CITY OF PORTLAND BUILDING PERMIT

PERMIT ID: 2013-00371

80 WILLIAM ST

has permission to **Kitchen and first floor bathe remodel.**

FOOTING DETAIL:

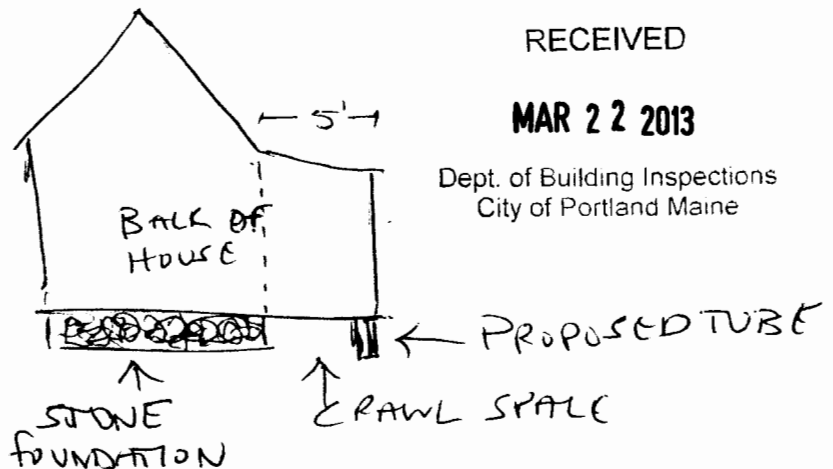
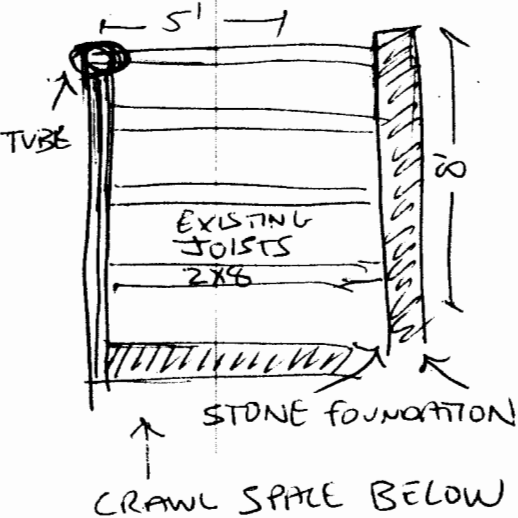
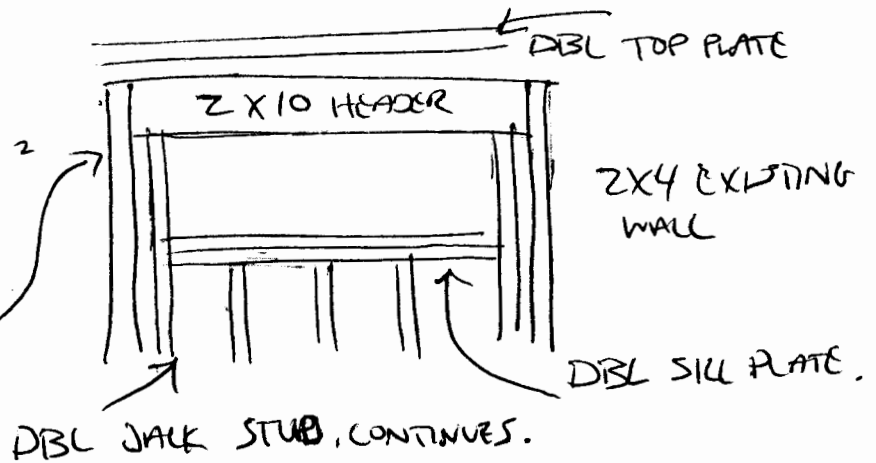
- Is the existing stairwell being renovated at all; is the storage room under an second floor stairwell?
- Draw a floor plan showing where the kitchen is in relation to the remainder of the building
- How close is the window opening to the property line, is the header on a bearing wall/ how many floors above?
- Draw the existing "steel footing" vs the proposed "Sona tube", why is this being replaced?
- What is the headroom/ fixture clearances in the proposed bathroom; is there a window or ventilation?
- Does the existing structure have smoke and carbon monoxide detectors?

-The existing 4" steel tube footing has rusted and sunk, presuming it's not below frost level. New sona tube would be on undisturbed soil 48" below grade, 12" width and will support pressure treated 6"x6" post attached with Simpson post base.
